Consultation Response from KC, Conservation & Design**2024/90160 Ashfield Hotel, 95, New North Road, Huddersfield, HD1 5ND****Erection of single storey quarter house (Listed Building within a Conservation Area)****Date Responded: 28.3.2024****Responding Officer: Sue Brooks****Responding Ref: HUD 27/1437**

Project Name and Address
**PROPOSED
SINGLE STOREY QUARTER HOUSE
AT 95 NEW N ROAD
FOR MR SETHI**

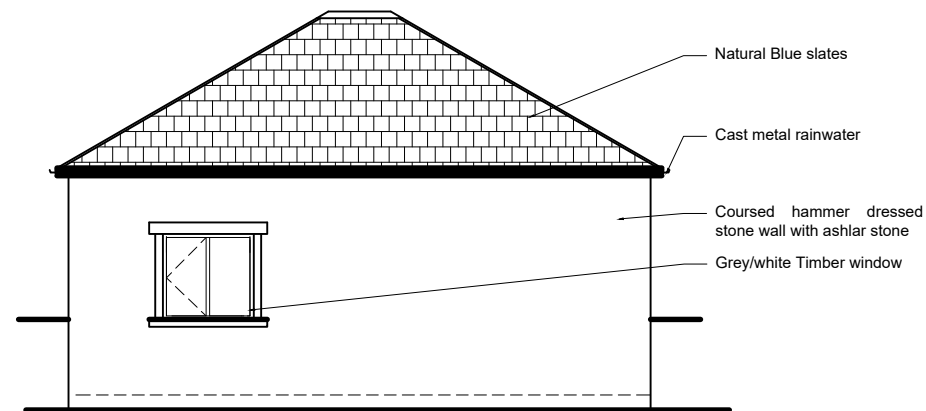
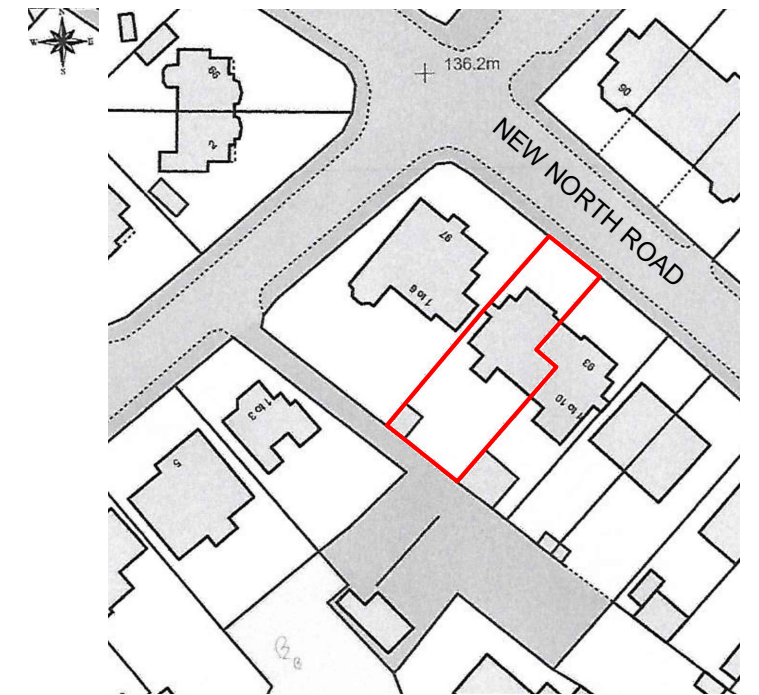
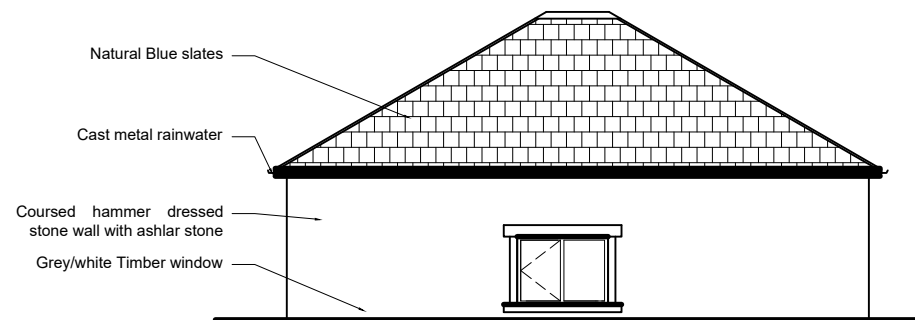
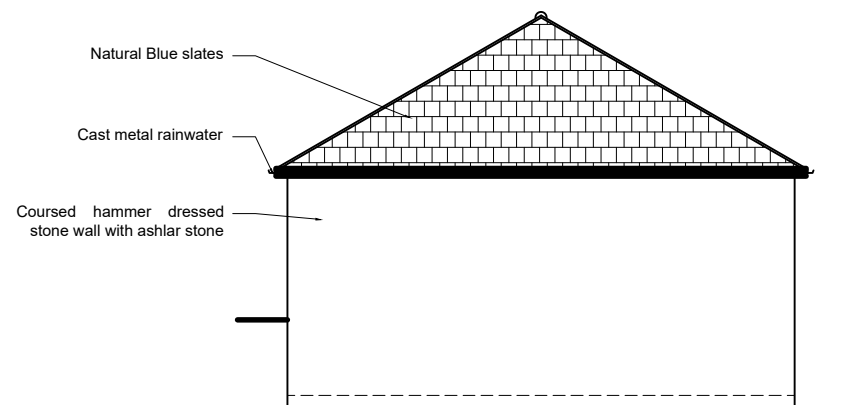
The proposed building is constructed in coursed hammer dressed stone external walls, ashlar window and door surrounds, natural blue slate hipped roof with cast-iron gutters, and timber windows and doors. Although the building is simple in design in material to match those used for the host building, we have concerns about the principle of this development which will cause less than substantial harm to the setting of the listed building by the construction of another building within a relatively small garden.

SITE PLAN (SCALE 1:500)

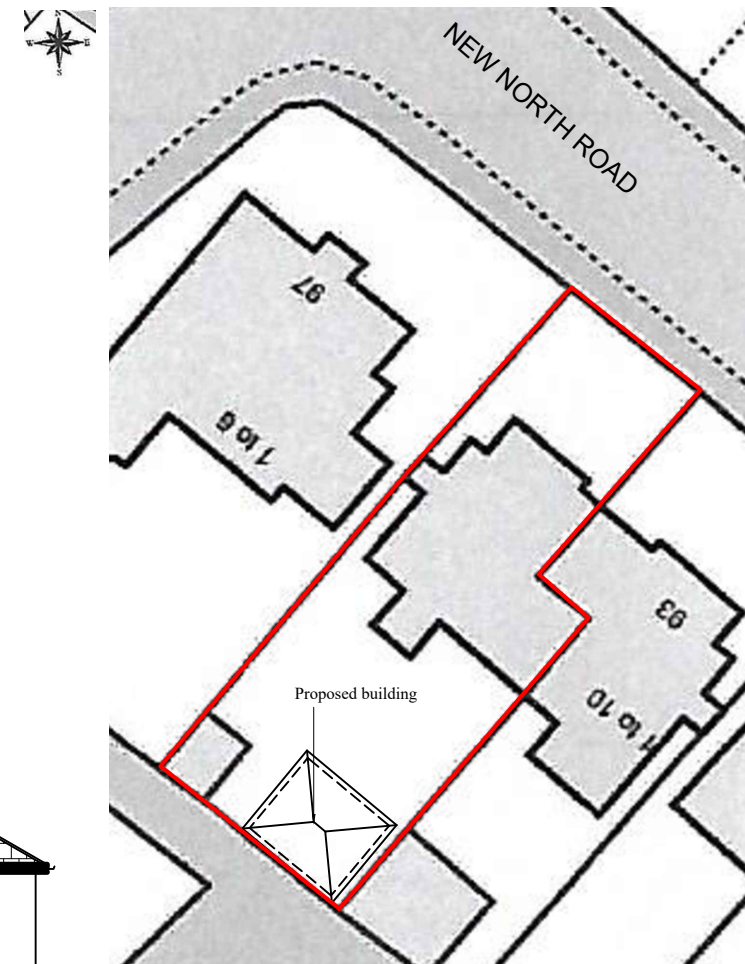
We do not feel that the construction of a building in the rear garden has been clearly justified and would recommend that the provision of suitable accommodation within the existing building is explored instead. We would suggest that this would also allow staff to be more readily available.
